RFI

RFI #: 109
 Date: 4/16/2012
 Job: EB-02 Keller Springs Lofts
 Phone: 877-777-5115

CC: Trent Perkins (Parkin Perkins Olsen), Enviro Design Landscape
 Subject: Elevation Discrepancies

Keller Springs Lofts
 EMBREY PARTNERS, LTD
 ADDISON, TEXAS

4L OF 6

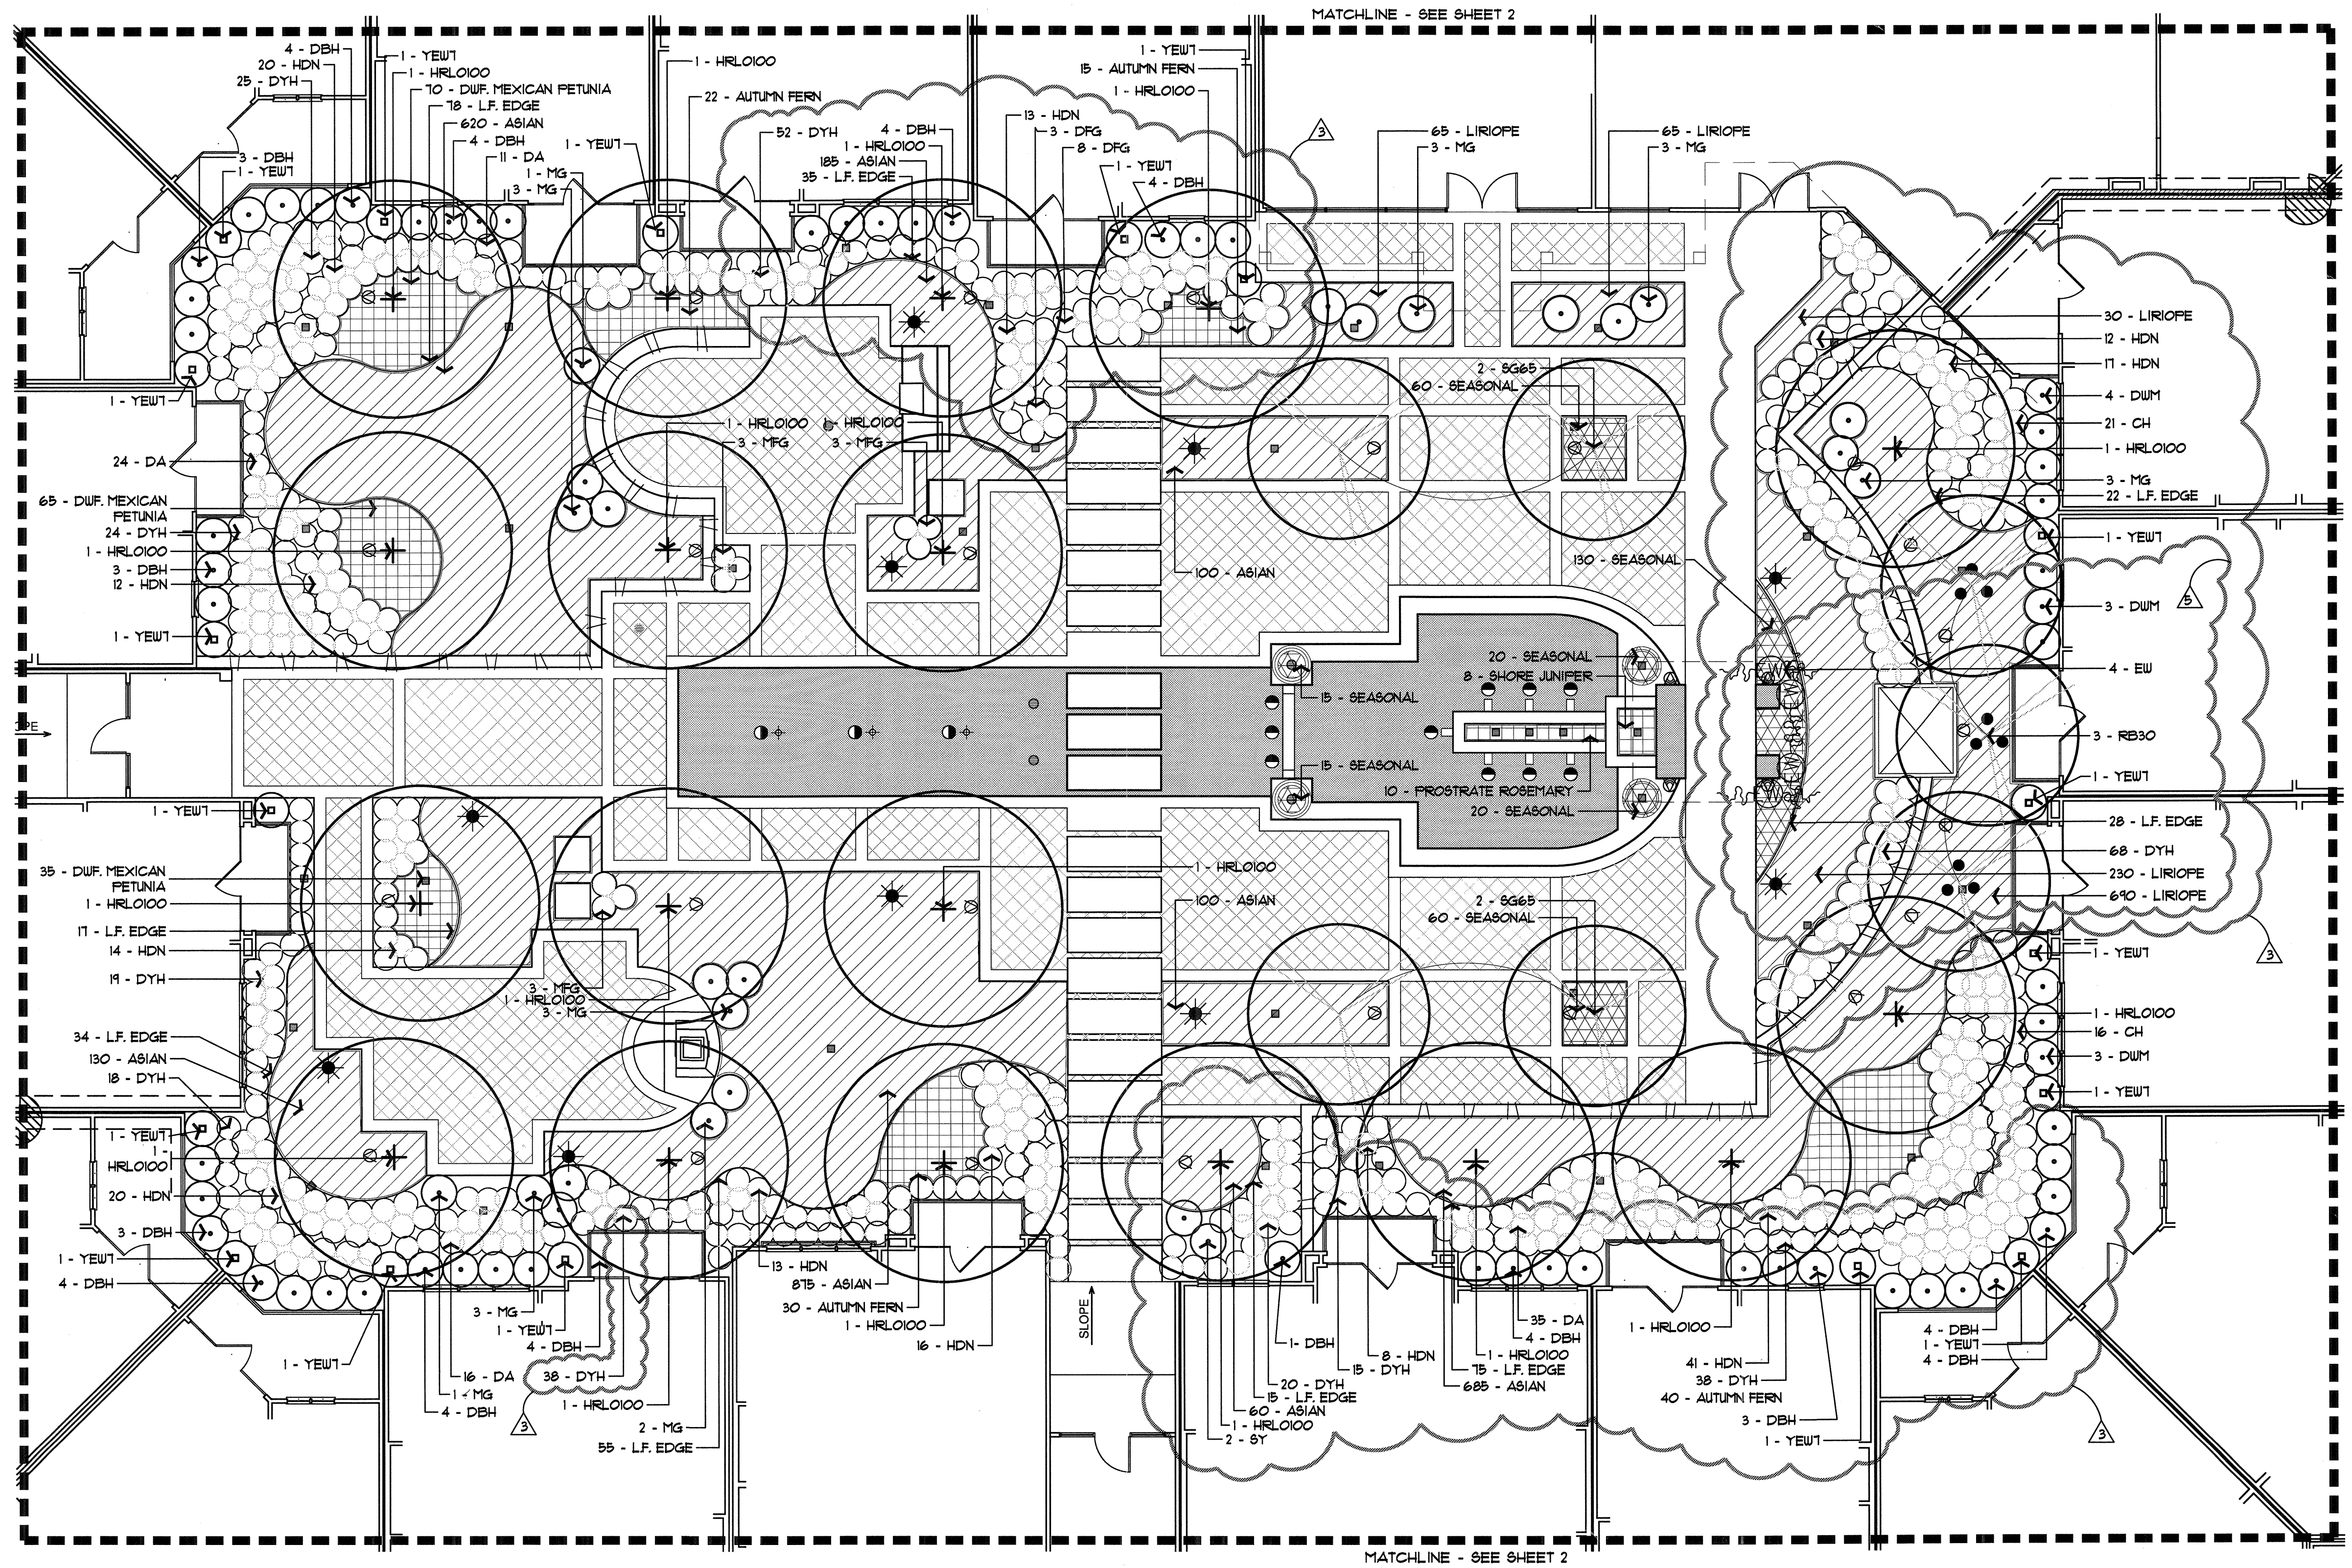
Request: Date Required: 2/3/2012
 Our pool contractor has proposed a change in location and elevation for the fountain equipment vault. Attachment # 1 shows RFI for the location of the CF panel in the courtyard. Attachment #2 shows proposed relocation of the vault and shows location of CF panel. Attachment #3 is a background e-mail. Attachment #4 is the detail sketch from the pool contractor.

The relocation of the vault is acceptable to us so long as it is positioned so that the River Birch can stay in place. The Dwarf Yaupons can terminate where they meet the new vault location and groundcover and be filled in around the front. We will revise our drawings and submit revised sheets which will incorporate RFI #35 as well.
